Our ref: HA/2014/116082/01-L01
Your ref: LU/253/14/DOC
Date: 09 September 2014

**APPLICATION FOR APPROVAL OF DETAILS RESERVED BY CONDITIONS 8 (SURFACE WATER DRAINAGE), 9 (DISCHARGE OF WATER FLOWS), 10 (FOUL DRAINAGE), 17 (CONSTRUCTION METHOD STATEMENT), 18 (CONSTRUCTION COMPOUND), 20 (VEHICLE WHEEL CLEANING), 22 (SPECIFICATION OF LAYOUT FOR ROADS, FOOTPATHS, CYCLEWAYS AND PARKING AREAS), AND 29 (MATERIALS AND FINISHES) FOLLOWING A GRANT OF PLANNING PERMISSION LU/355/10/:
COURTWICK LANE LAND SOUTH OF RAILWAY LITTLEHAMPTON BN17 7PD**

Environment Agency Position

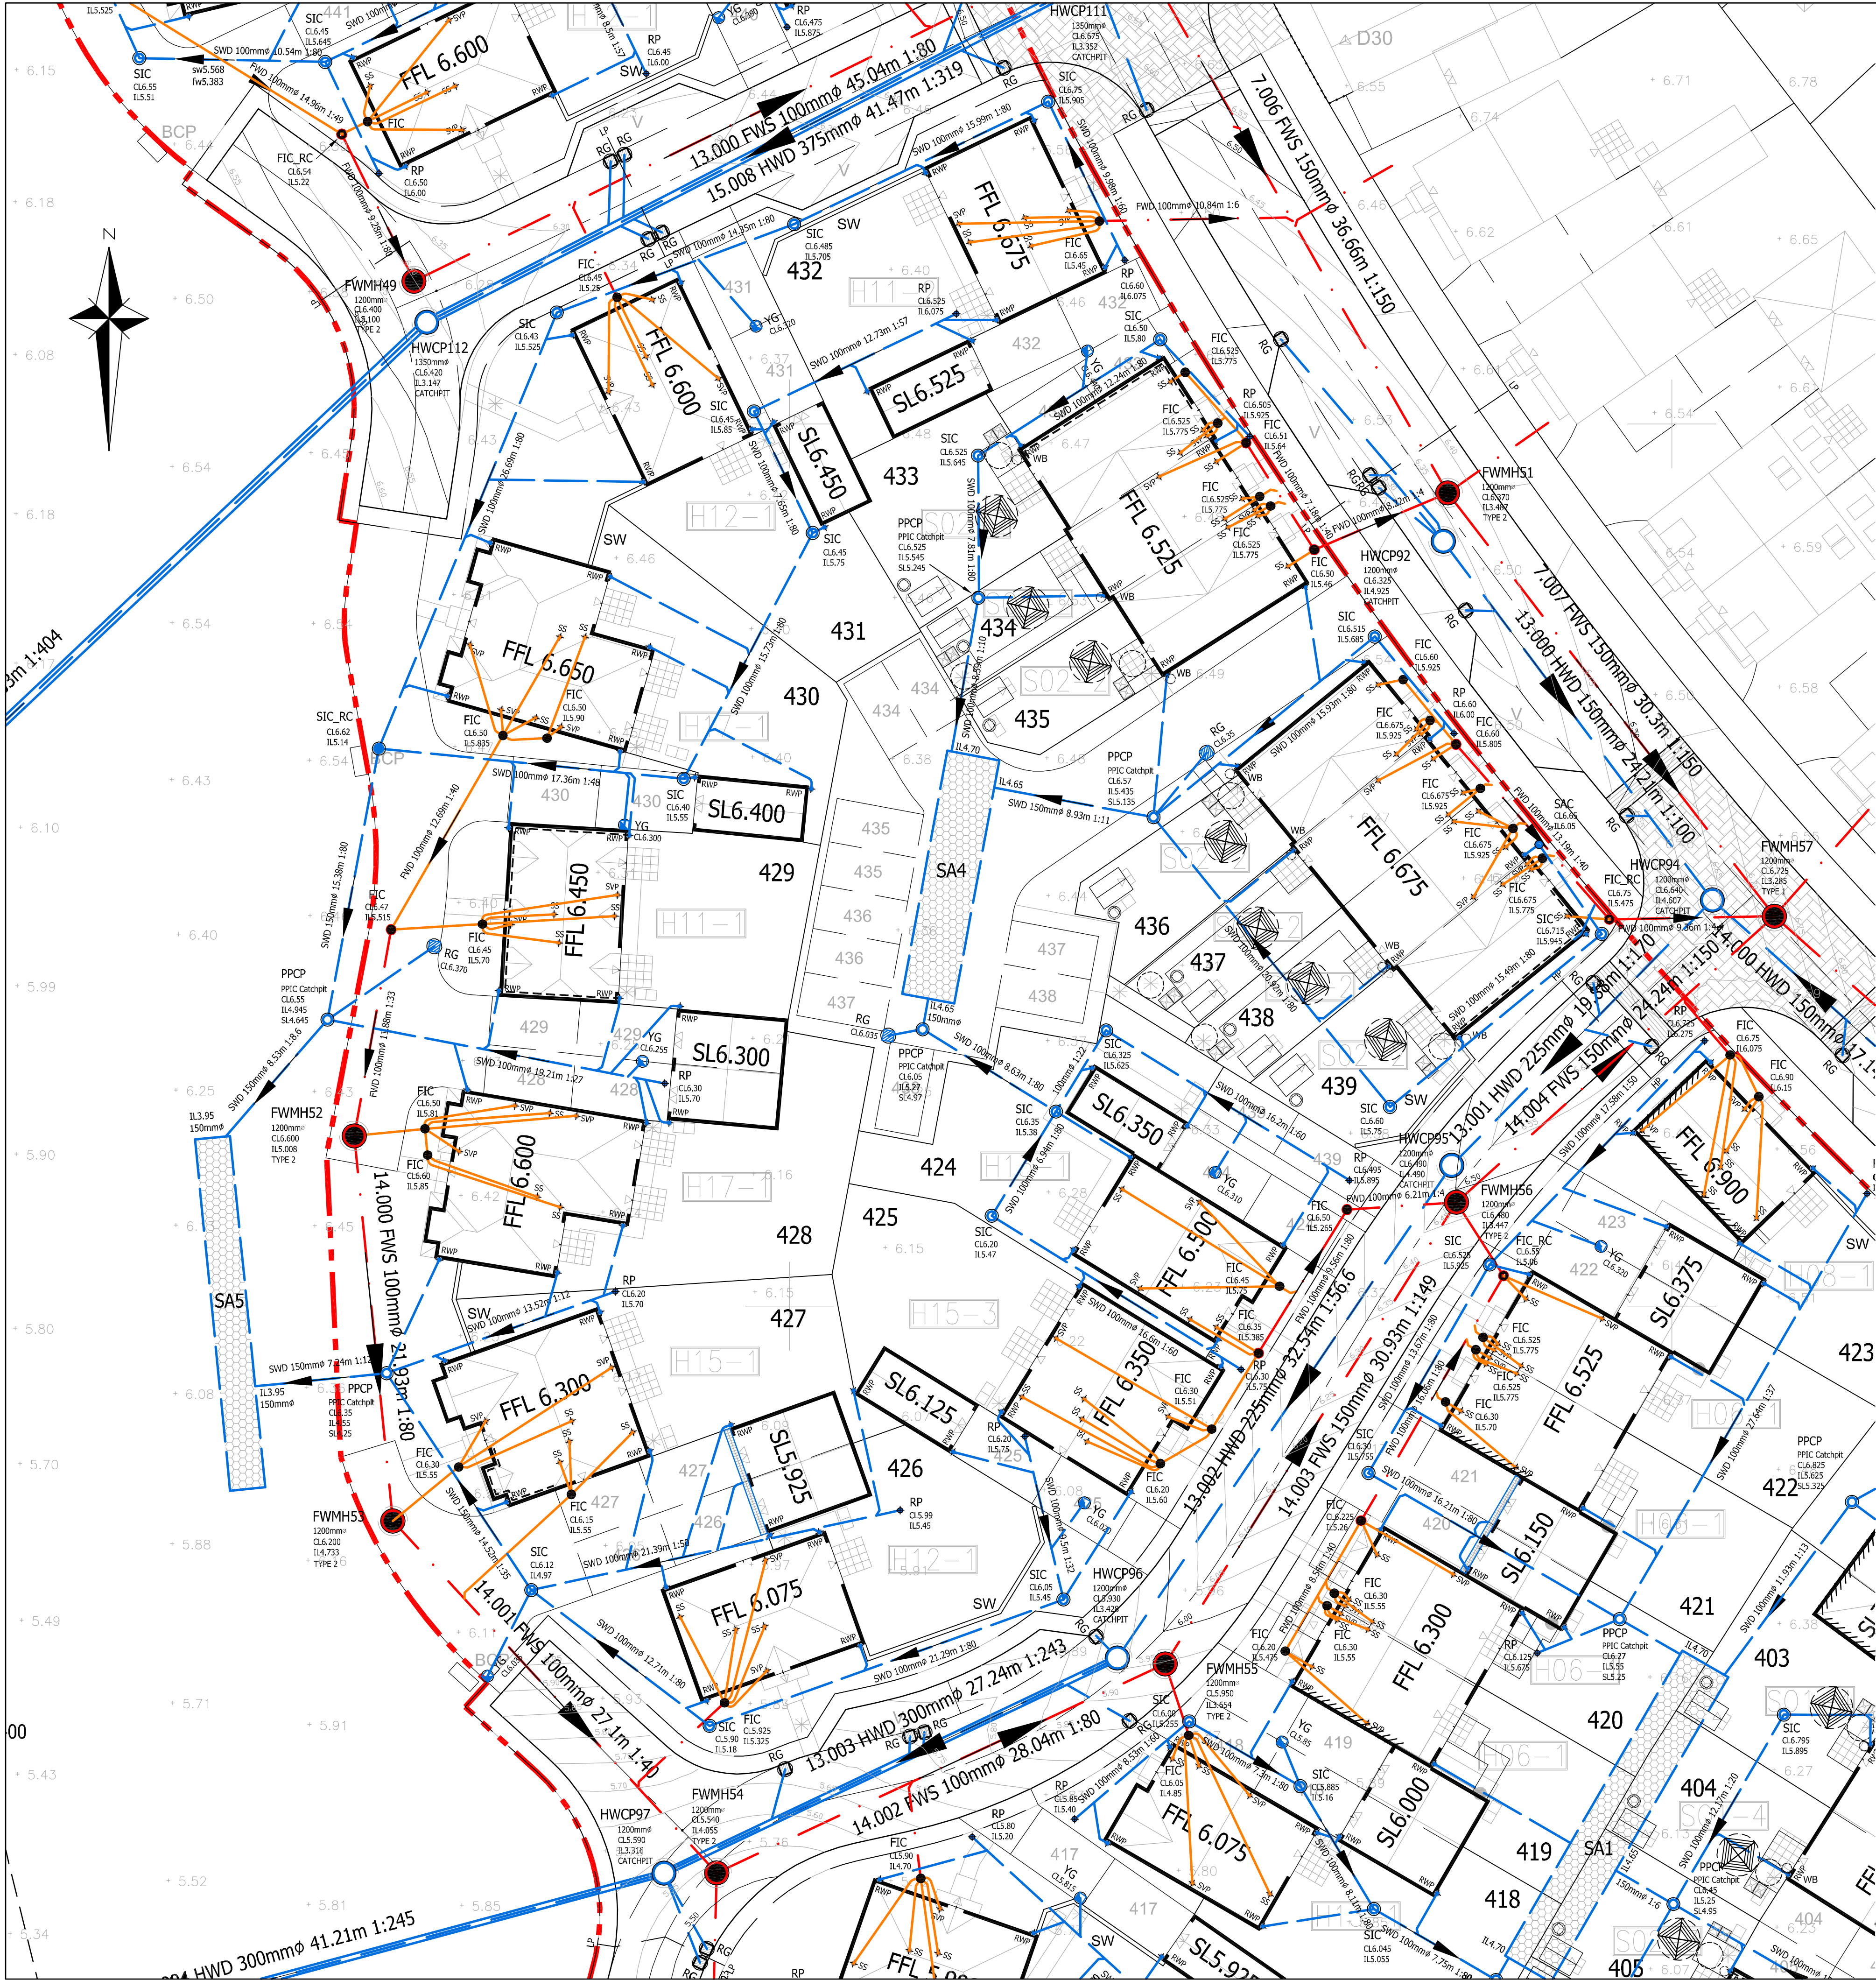
We are unable to recommend that condition 8 (surface water) is discharged at this stage, until we have seen the results of the intrusive investigation for the site as required by Condition 30 (land contamination) on planning permission LU/355/10. Without this information we consider the scheme presents an unacceptable risk to water quality.

In relation to flood risk, the applicant is proposing to discharge to soakaway. We would therefore recommend that you consider the advice of your Council's own Engineers in relation to the discharge of this condition, who we understand have raised concerns regarding soakaway capacity.
